City of Portland, Maine - Building or Use Permit Application
 389 Congress Street, 04101 Tel: (207) 874-8703, Fax: (207) 874-8716

Permit No: 09-1240	Issue Date:	CBL: 415 B006001
------------------------------	--------------------	----------------------------

Past Use: Telecommunications Tower	Proposed Use: Telecommunications Tower - install a backup diesel generator w/a 5' x 8' pad	Permit Fee: \$50.00	Cost of Work: \$2,500.00	CEO District: 4
Proposed Project Description: install a backup diesel generator w/a 5' x 8' pad		FIRE DEPT: <input type="checkbox"/> Approved <input type="checkbox"/> Denied	INSPECTION: Use Group: Type	
		Signature:	Signature:	
PEDESTRIAN ACTIVITIES DISTRICT (P.A.D.)				
Action <input type="checkbox"/> Approved <input type="checkbox"/> Approved w/Condition <input type="checkbox"/> Denied				
		Signature:	Date:

Dept: Zoning **Status:** Approved with Conditions **Reviewer:** Ann Machado **Approval Date:** 12/01/2009

REVISION NOTES: CHANGED DIESEL GENERATOR LOCATION  
REVISION NOTES: ORIGINAL ISSUE

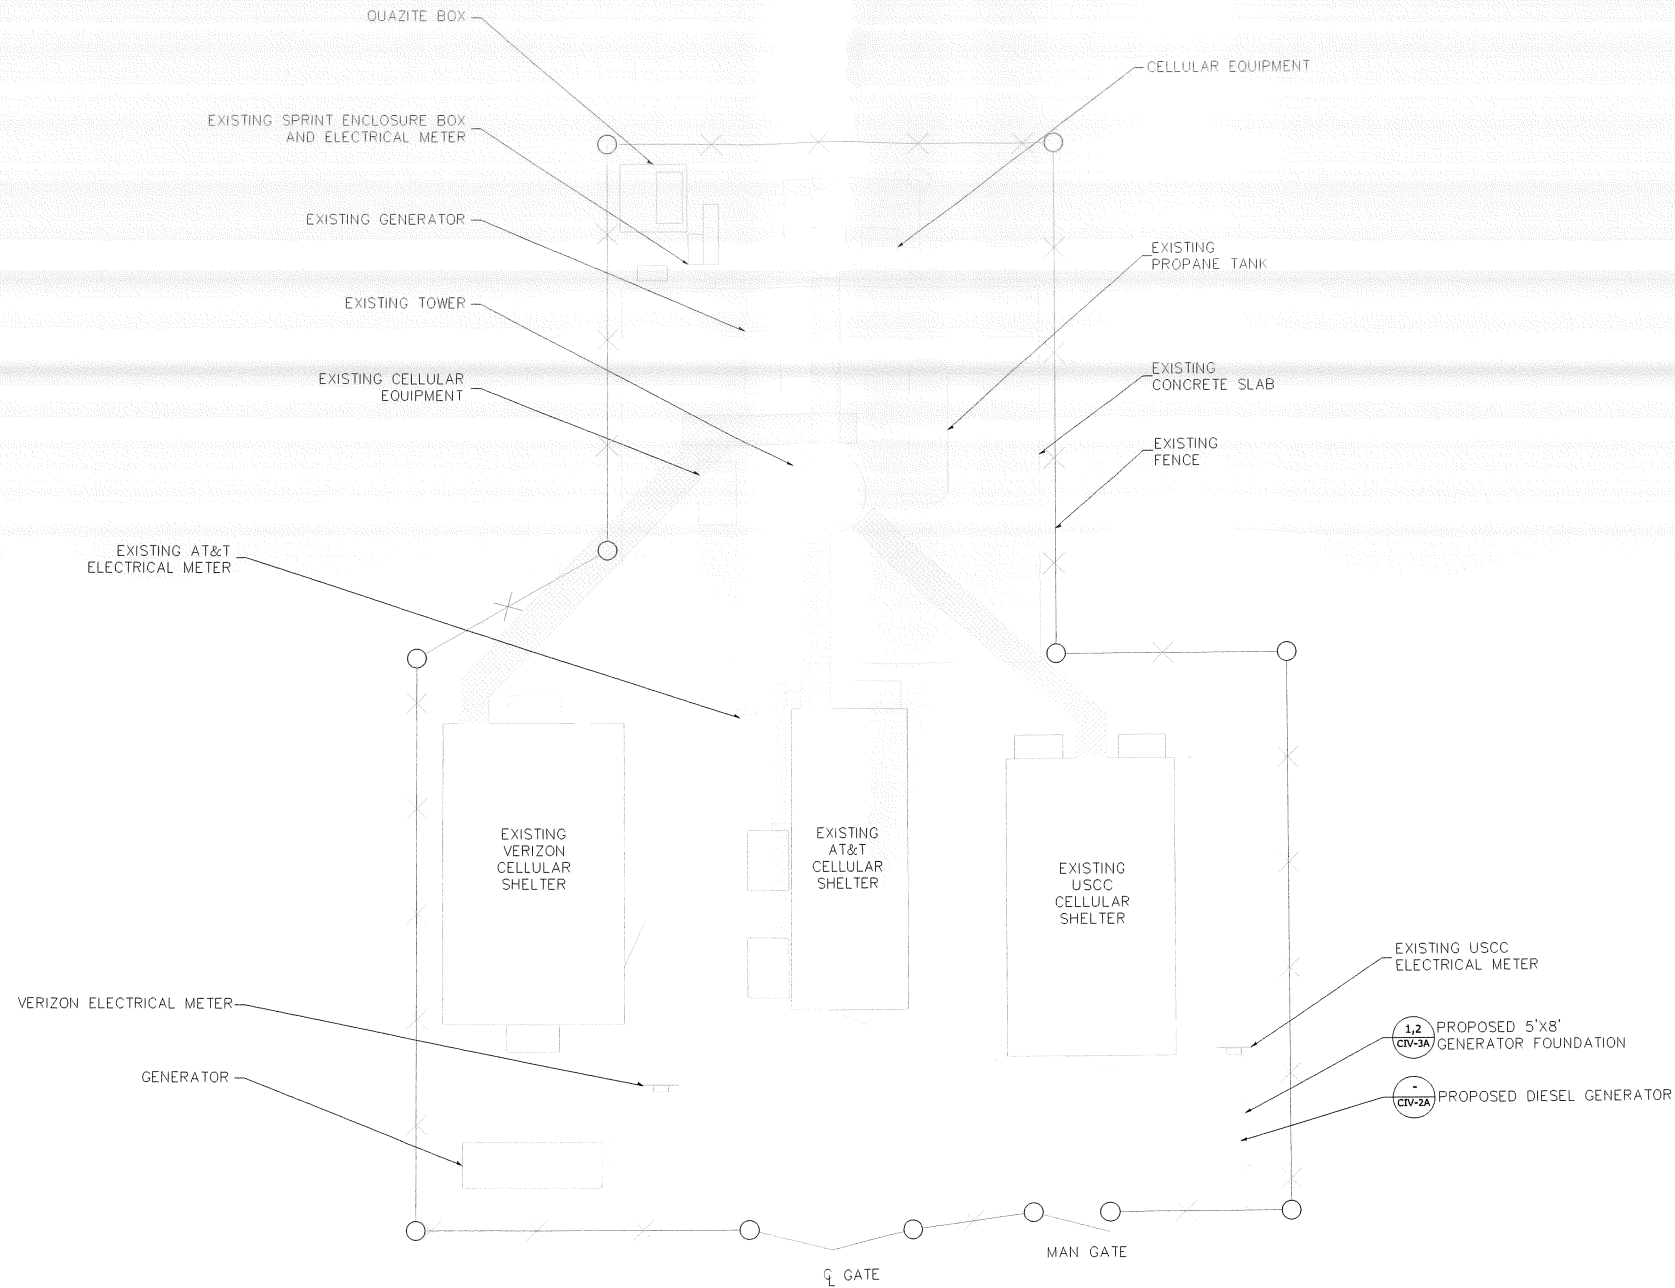
Note: Section 14-252(a)(3) states the maximum permissible sound levels at 70 dBA between 7 AM & 10 PM and 55 dBA between 10 PM and 7 AM. Information shows at 23' it is 68 dBA and at the property line (64') the dBA is 51.32. **Ok to Issue:**
